MEMORANDUM

Re: Narrative Describing Revised Driveway Design to Murray Residence, 4803 Forest Ave SE Application # 2012-069

Date: April 29, 2021

**SITE PLAN DRIVEWAY OPTION #2**

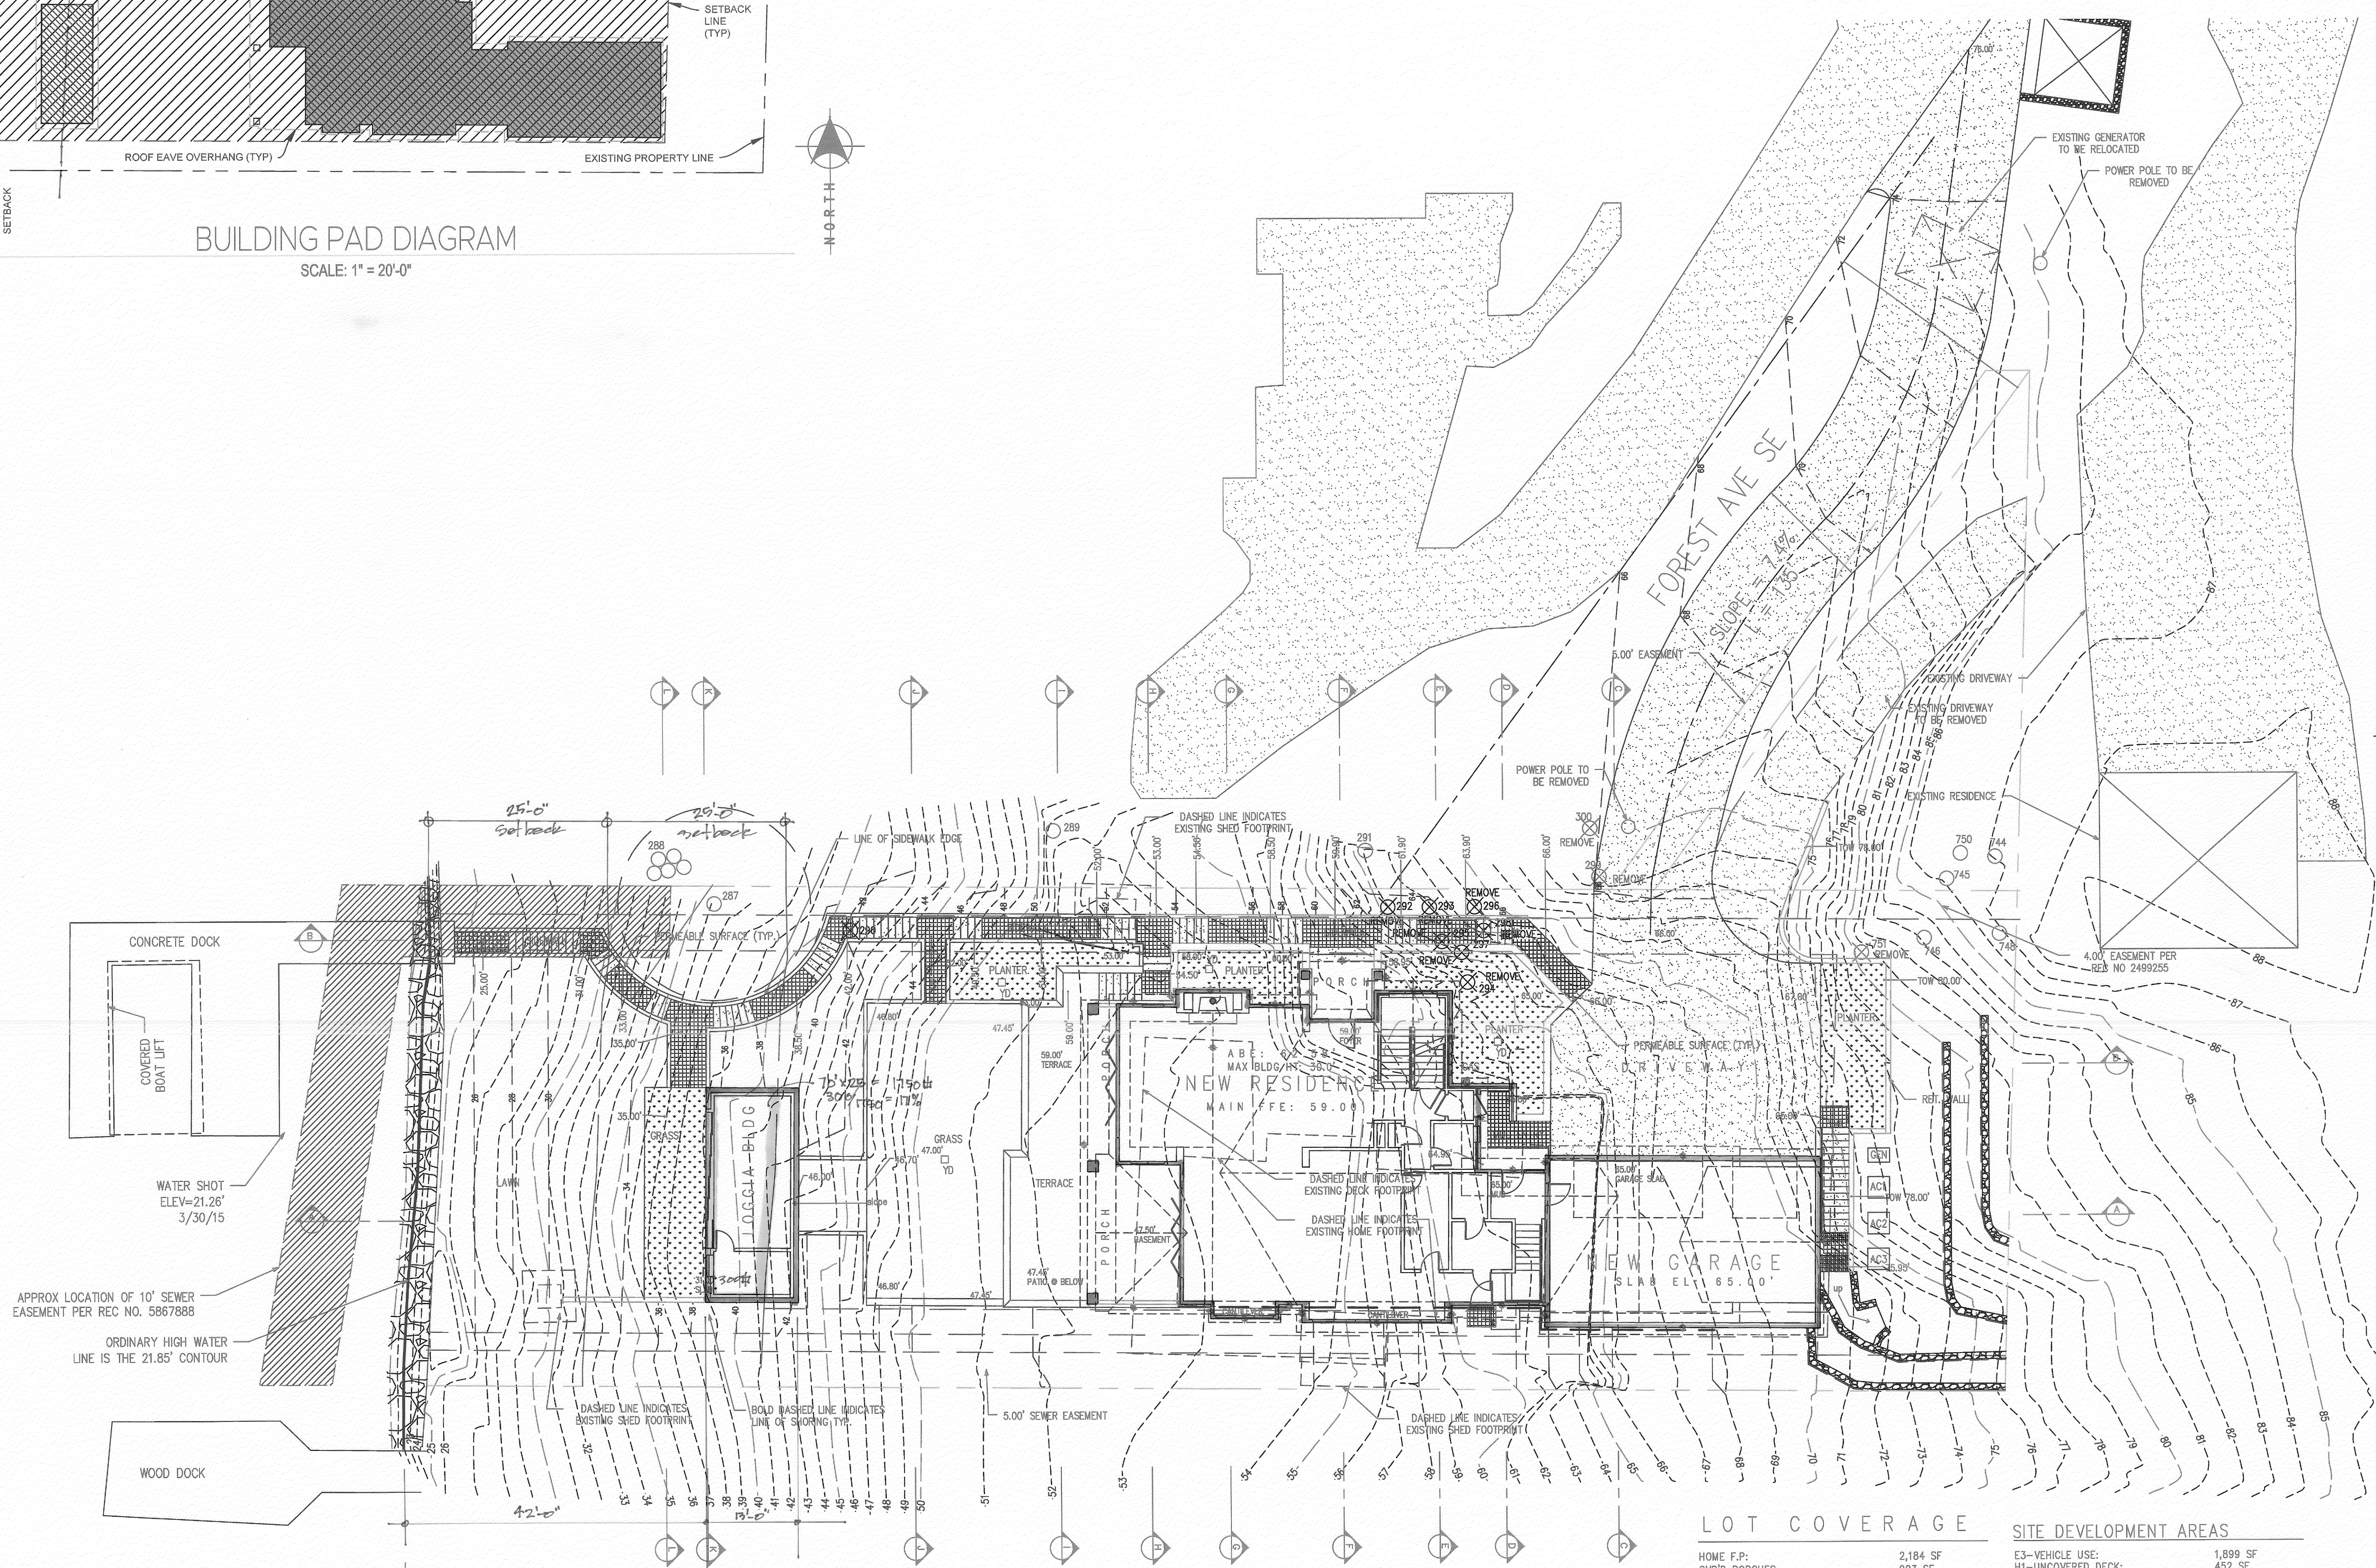
The prior permit application for the SFR building permit at 4803 Forest Ave SE included a private driveway on private lands that greatly exceeded 20 percent slope. Under MIMC 19.09.040.G., no private access road or driveway is allowed to exceed a gradient of 20 percent. In addition, the Mercer Island Fire Marshal requested that the new driveway be at least 16 feet wide. The accompanying resubmittal package responds to these concerns.

Similar to the relatively new driveway providing access to the home at 4753 Forest Ave SE, the new driveway design for the Murray Residence is largely located within an under-developed City right-of-way of Forest Ave SE. This location allows for a 16-foot wide driveway, with a slope of 7.4 percent.

The proposed driveway location will require the Murray Residence project to relocate an existing backup generator and enclosure for the City's nearby sewer pump station; the new proposed location is slightly to the north and still within the Forest Ave SE right-of-way. In addition, the removal of two power poles, to be replaced by underground service lines, is required. Additional utilities may also need to be relocated. The Murray Residence project would be responsible for the cost of these relocated facilities.
